Rezoning Transportation Analysis
Petition Number: Insert Zoning Petition #2021-026
General Location Identifier: Tax ID 01914104

From: Robyn Byers, Ph.D.
 Robyn.Byers@ci.charlotte.nc.us
 704-336-7404

Date	Description
02-25-21	First Review (EL)
03-25-21	Second Review (KP)
04-28-21	Third Review (EL)

CITY OF CHARLOTTE, MECKLENBURG COUNTY, NORTH CAROLINA
 REZONING SUBMITTAL
HENDRICK NORTHLAKE
 SITE PLAN - RPZ-2021-026

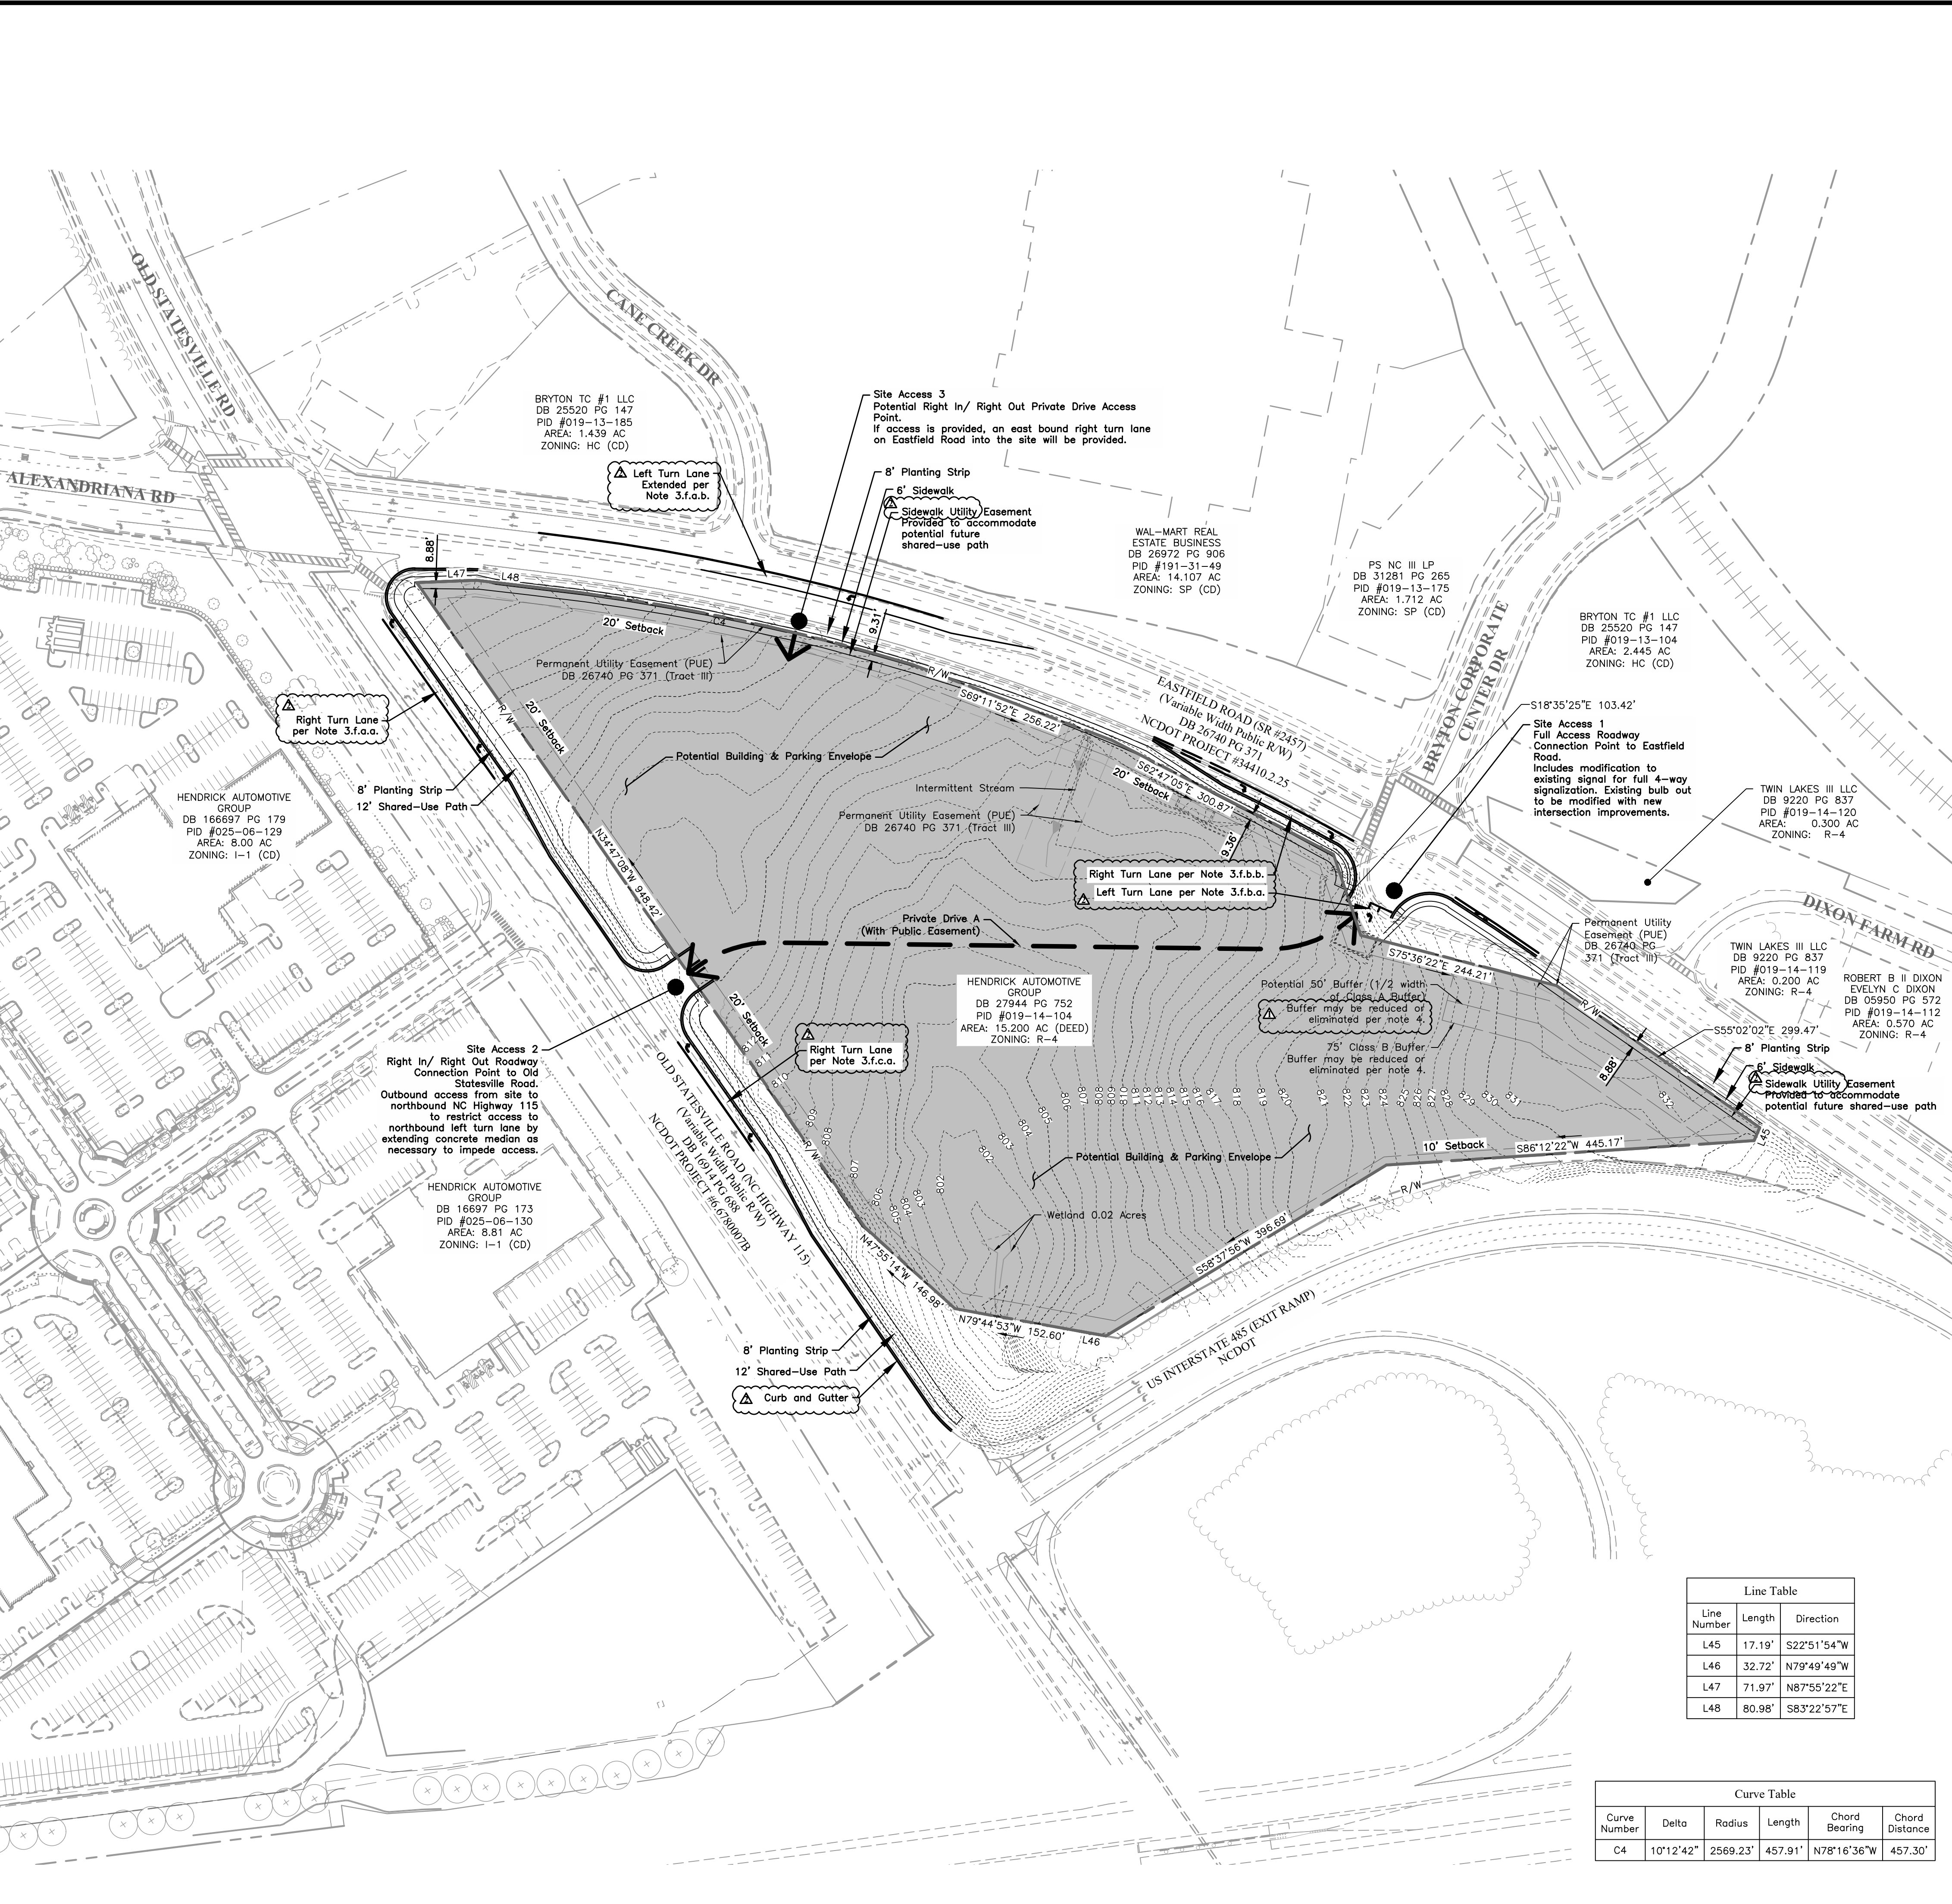
1. **Curbline:**

- a. ~~Eastfield Road: The future location of curb and gutter is in its existing location.~~
- b. ~~Old Statesville Road: The future location of curb and gutter needs to be installed at the existing edge of pavement, per Chapter 19-174 of the City Code.~~

~~**Update to Comment as a Result of the 03/16/2021 Site Plan:** Revise the site plan and conditional notes to commit to the construction of this curb line on Old Statesville Road.~~

2. **Traffic Study:**

~~**Update to Comment as a Result of the 03/16/2021 Site Plan:** Please include the transportation improvements, established in the TIS, in the conditional notes. Additionally, revise the site plan to reflect these transportation improvements at the relative intersections and site accesses.~~

3. ~~Site plan and conditional note (Section 3.a.) revisions are needed to commit to construct an 8-foot planting strip and 12-foot shared-use path, per Chapter 19-174 of the City Code and the Charlotte BIKES Policy, along Old Statesville Road and Eastfield Road. The site plan shall label and dimension both items from the back of curb and gutter and road centerline.~~

Update to Comment as a Result of the 03/16/2021 Site Plan: Revise the site plan by changing the "Public Access Easement" call out, along Eastfield Road, to "Sidewalk Utility Easement".

4. ~~Revise the site plan to correct the road name "Alexanderana Road" to "Eastfield Road." Alexandriana Road transitions to Eastfield Road, east of the intersection with Old Statesville Road.~~

5. **Outstanding Comment:** A site plan note specifying dedication and fee simple conveyance of all rights-of-way to the City before the site's first building certificate of occupancy is issued is needed. CDOT requests rights-of-way set at 2' behind back of sidewalk where feasible. The site plan shall label and dimension the proposed right-of-way to be dedicated from the road centerline.
6. **Outstanding Comment:** A site plan note specifying that all transportation improvements will be approved and constructed before the site's first building certificate of occupancy is issued is needed. The petitioner may phase transportation improvements if said improvements and phasing are explicitly described in site plan notes.
